TOWN AND COUNTRY PLANNING ACT 1990

FULL

Reference: H16-1129-23 **Date of Decision:** 5th March 2024
Applicant: Mr D Roberts
75 Bourne Road
Spalding
Lincolnshire
PE11 1JR
Location: 75 Bourne Road Spalding
Description: Removal of existing conservatory and replace with one and half storey extension - Re-submission of H16-0727-23

09 / 1 - Proposed First Floor Schedule			
Name	Area	Perimeter	Comments
En Suite 3	14.90 m²	15.6 m	proposed
Grand total: 1	14.90 m²	15.6 m

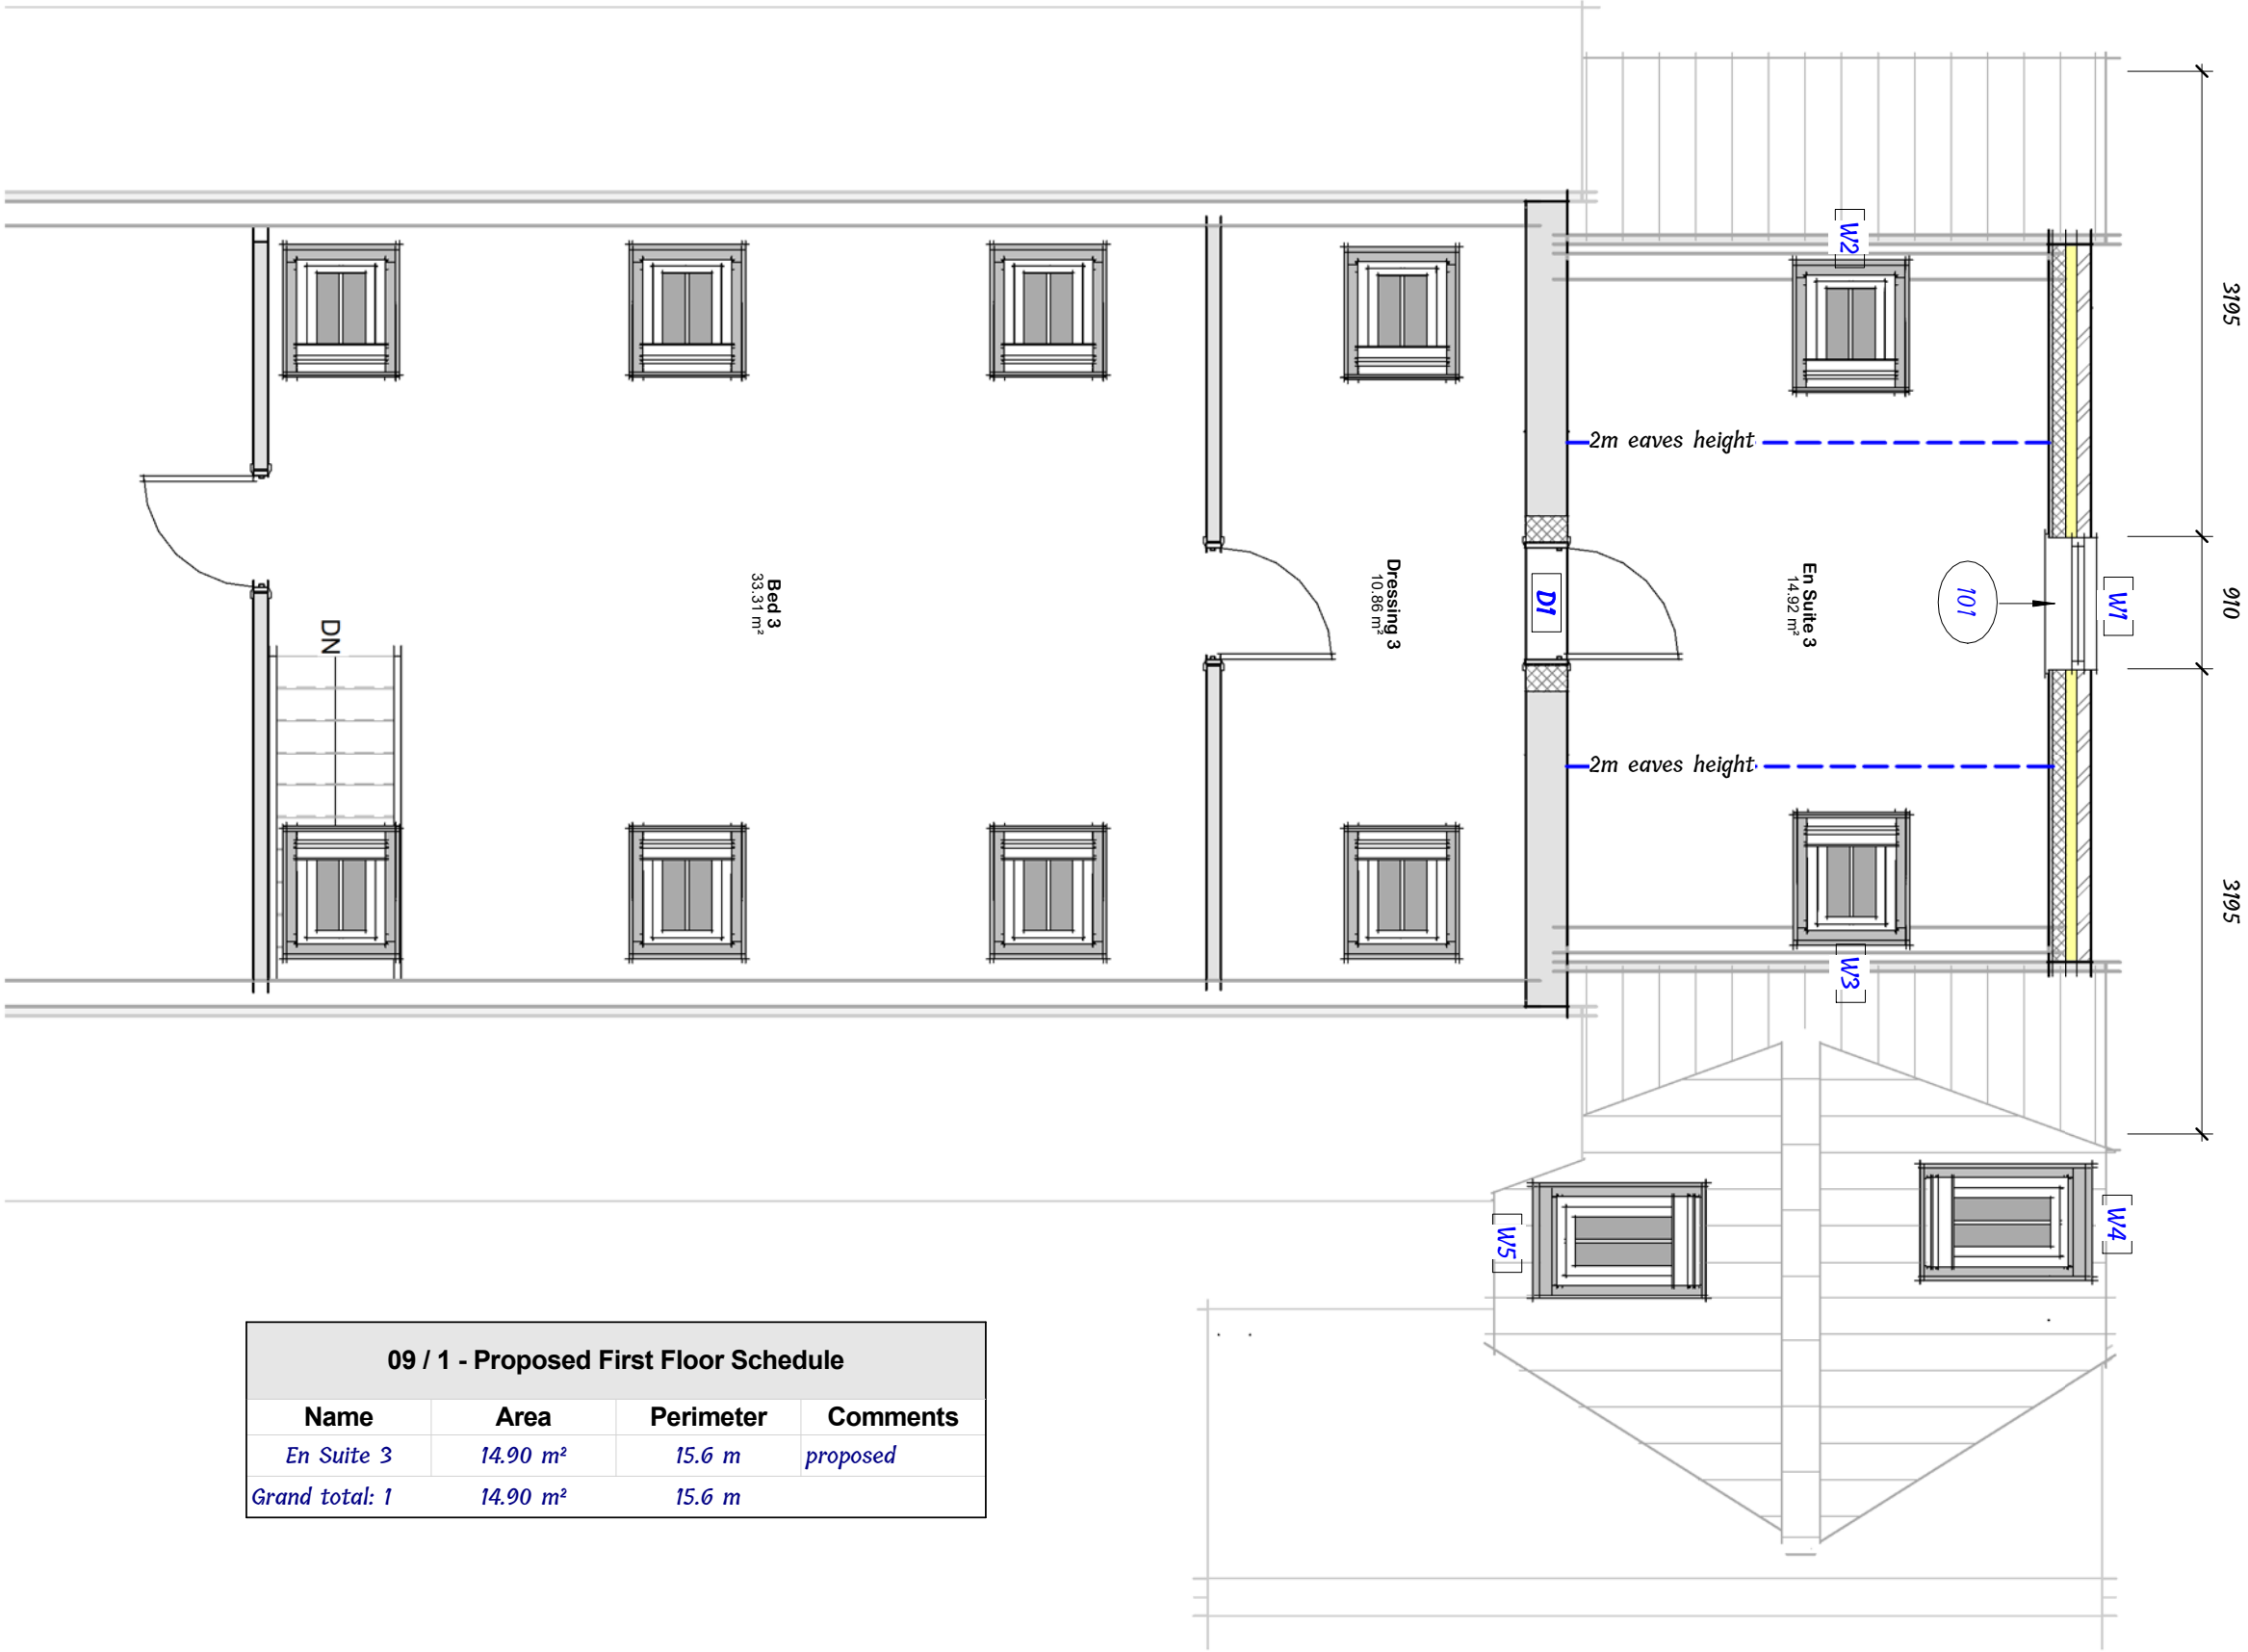
- 4 Notwithstanding the details submitted, before any part of the development hereby permitted is occupied, the following window shall be obscure glazed with no opening part being less than 1.7m above the floor level immediately below the centre of the opening part. The obscure glazing shall be obscured to a minimum of Grade 5 glass and thereafter so maintained as such at all times:

- First floor window, serving the proposed en-suite to the rear elevation, as annotated as W1 on Drawing No: 2871-09 Rev: A
